From: Simon Davis
Sent: 08 November 2019 16:36
To: Simon Randell [REDACTED]
Cc: Conservation Officer <Conservation.Officer@arun.gov.uk>
Subject: RE: The Royal Hotel BR/326/18/PL and BR/257/19/PL

From: Simon Randell [REDACTED]
Sent: 29 October 2019 12:57
To: Simon Davis <Simon.Davis@arun.gov.uk>
Cc: Conservation Officer <Conservation.Officer@arun.gov.uk>
Subject: The Royal Hotel BR/326/18/PL and BR/257/19/PL

1. Approved Application BR/326/18/PL – You will have noted that the west wing is due to be substantially demolished ready for replacement walls etc. It is evident during the process of demolition that we have ended up proposing to leave small nib walls that are not only unsafe if left unsupported but they have no historic value. The client wishes to remove the few remaining small wall areas on this wing. Are you happy for them to do so?
2. Pending application BR/257/19/PLI – As the decision is due in a few days I wanted to check there wasn't anything other information you needed from us to assist with the application.

CLIENT	Metamorph Management LLP
PROJECT	The Royal Hotel, Bognor Regis
DATE	11/11/19
DRAWING TITLE	Proposed Lower Ground Floor

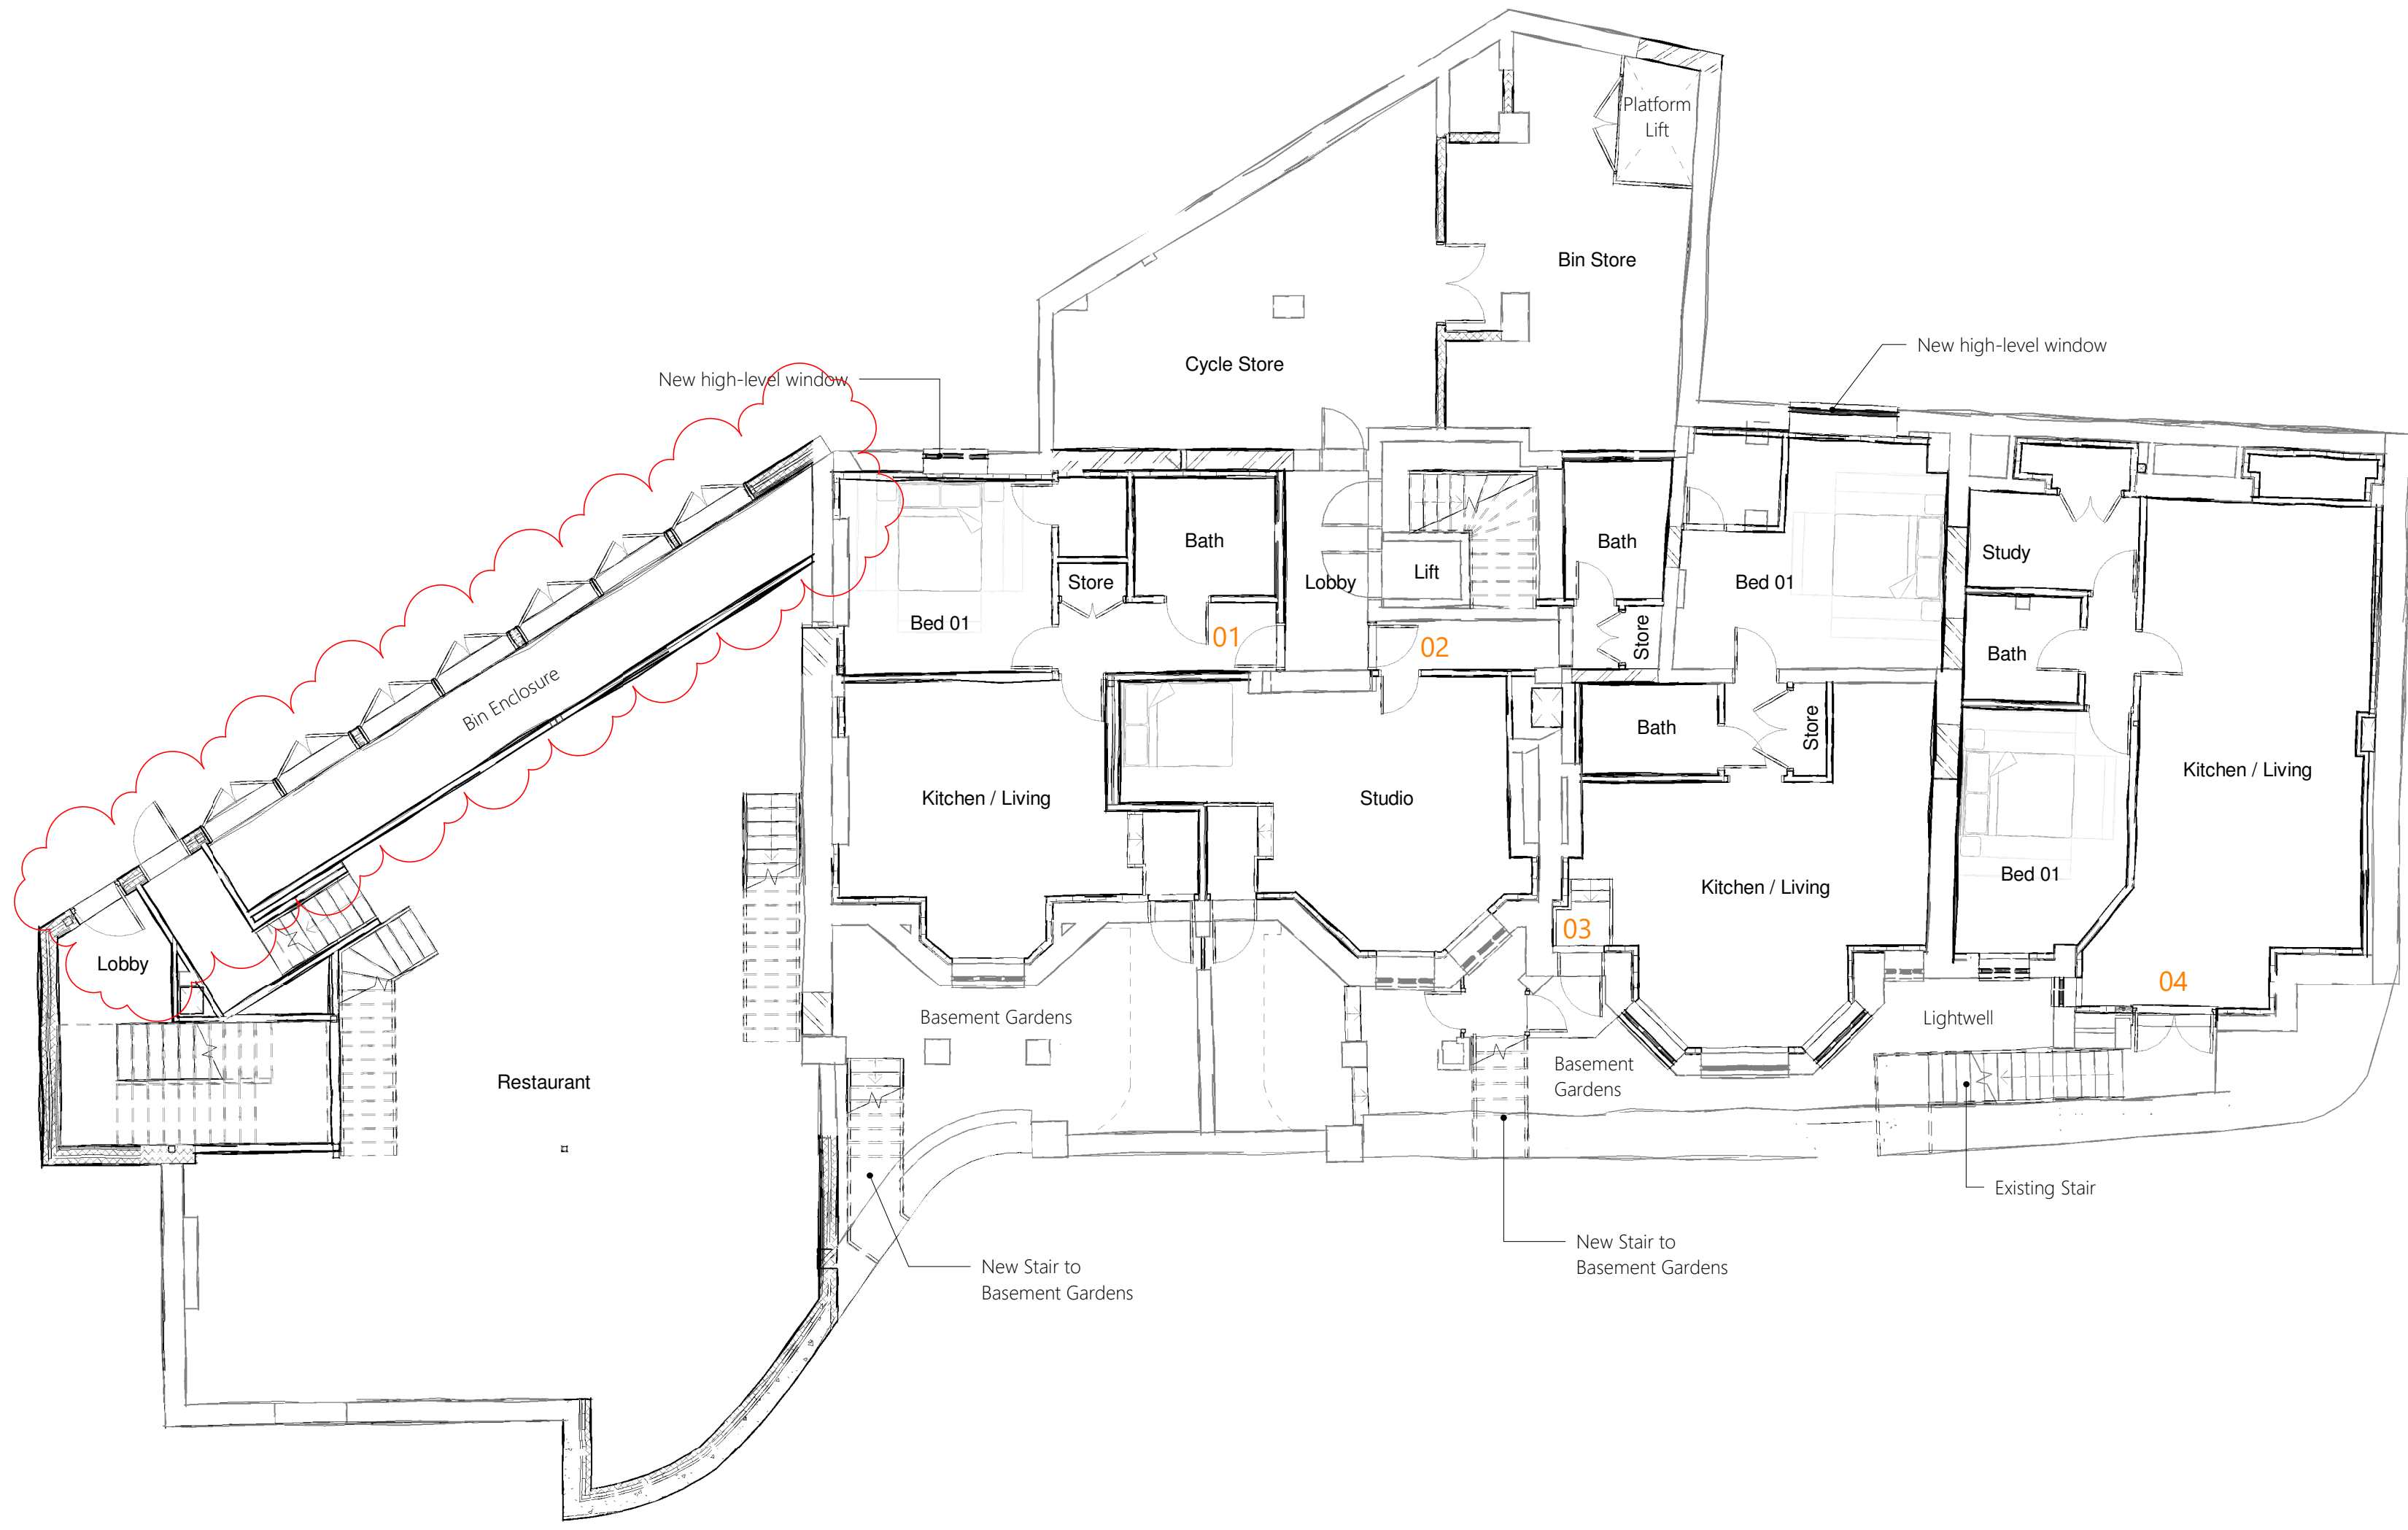
As to the nib walls, the only way to provide a formal response, would be for you to include the removal of these walls in the current application i.e. provide an amended version of the plan/s that refers to the removal of these. We can accept these without the need to reconsult/re-advertise the application although this may slightly delay my decision dependant on when you can get these to me.

I spoke with our Conservation Officer, Martyn White, yesterday and he informally agreed that these nib walls can be removed. I have also asked Martyn to provide his comments on the application so that I am able to advise of our likely recommendation.
